# *City of Albuquerque*

RE: CONCEPTUAL GRADING & DRAINAGE PLAN OF UNIVERSITY/I-25  
SUBDIVISION, RECEIVED FEBRUARY 3, 1988 FOR SITE DEVELOPMENT  
PLAN AND PLATTING APPROVALS (J-15/D34)

Roger A. Green, P.E.  
C.E./Hydrology Section

CONCEPTUAL DRAINAGE PLAN

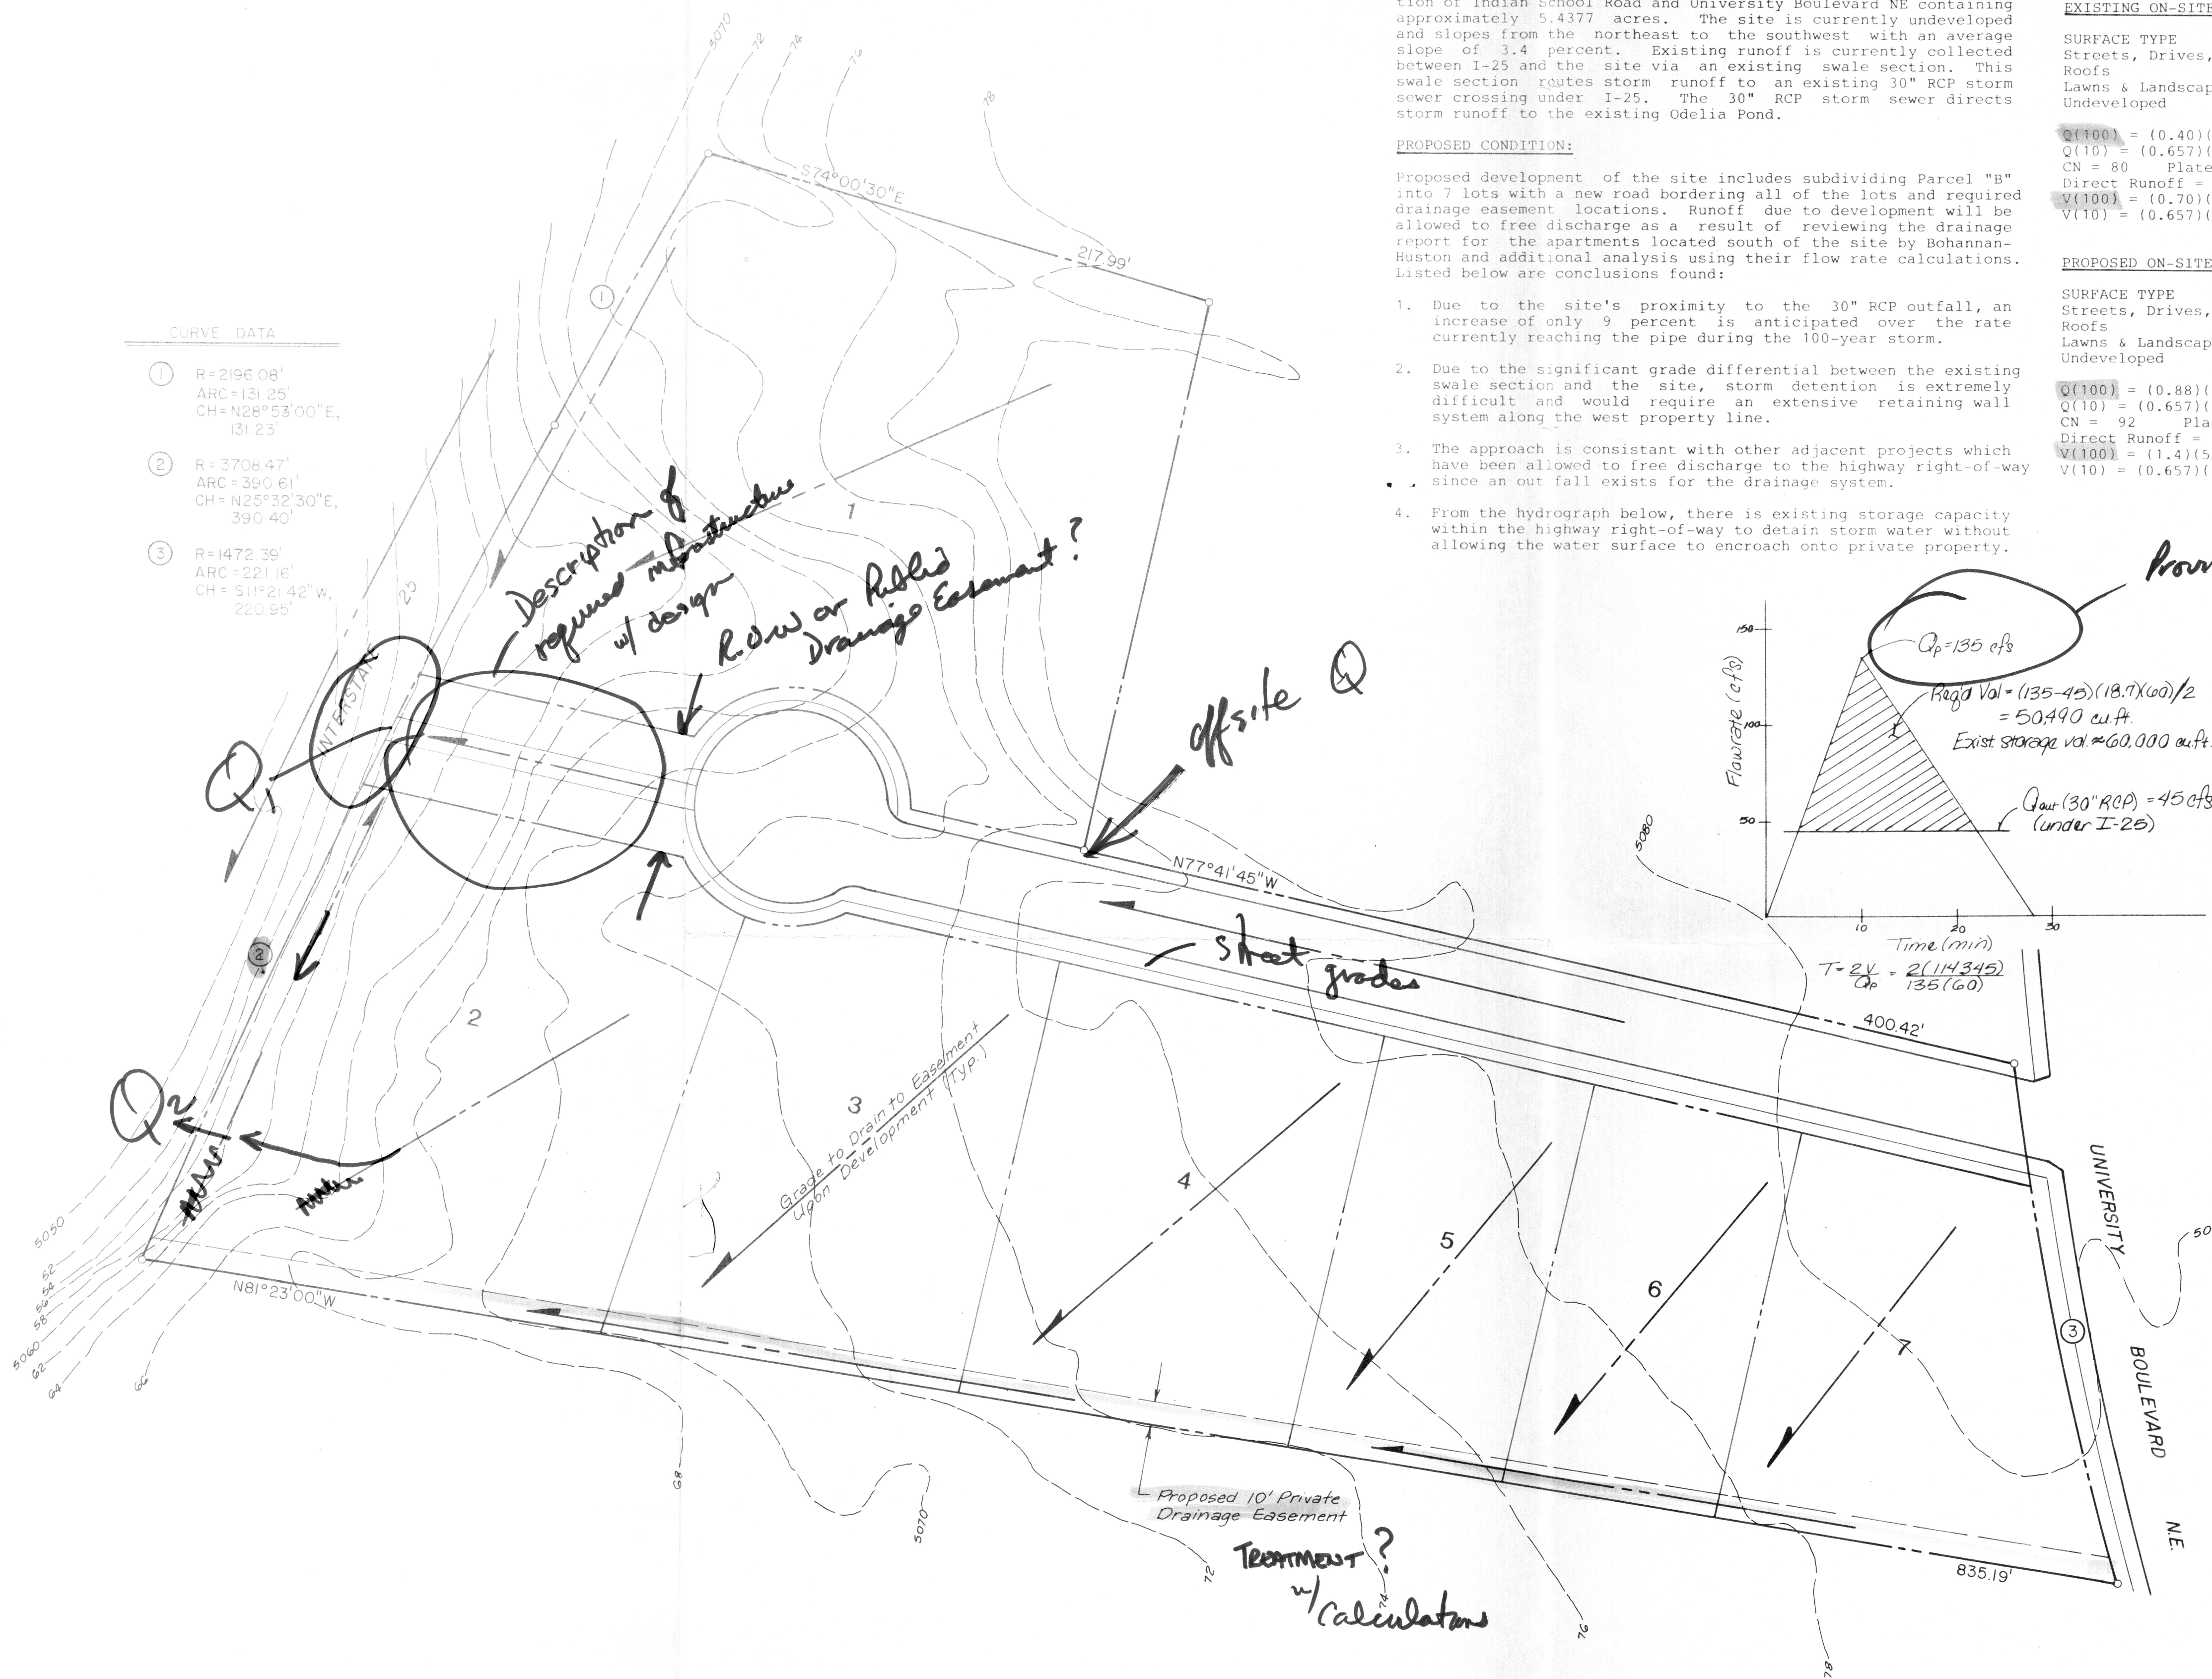
1. Provide a copy of the Flood Hazard Map on the Drainage Plan, or delineate on the plan view.
2. Provide an off-site watershed boundary map for the areas upstream contributing runoff to the I-25 outfall, and the area to the northeast of site draining to the proposed street.
3. Provide the off-site discharge rate of the adjacent area draining into the proposed street for the existing undeveloped and developed conditions.
4. Divide the on-site area into two separate drainage basins and show the discharge rate of each.
5. Label proposed Public right-of-way and drainage easements.
6. Provide preliminary design calculations and provide more details of required drainage systems outfalling to the I-25 right-of-way. Show what treatments are required.

7. Provide preliminary proposed street elevations and lot corner elevations.

I agree with the proposed drainage scheme and free discharge although prior to any final approval on infrastructure construction drawings and Final Plat, concurrence from the State Highway department will be required. An approved infrastructure list will be required by the DRB along with a Subdivision Improvements Agreement. A Site Development Plan must also be processed through EPC and DRB since the site is greater than five acres with C-3 zoning.
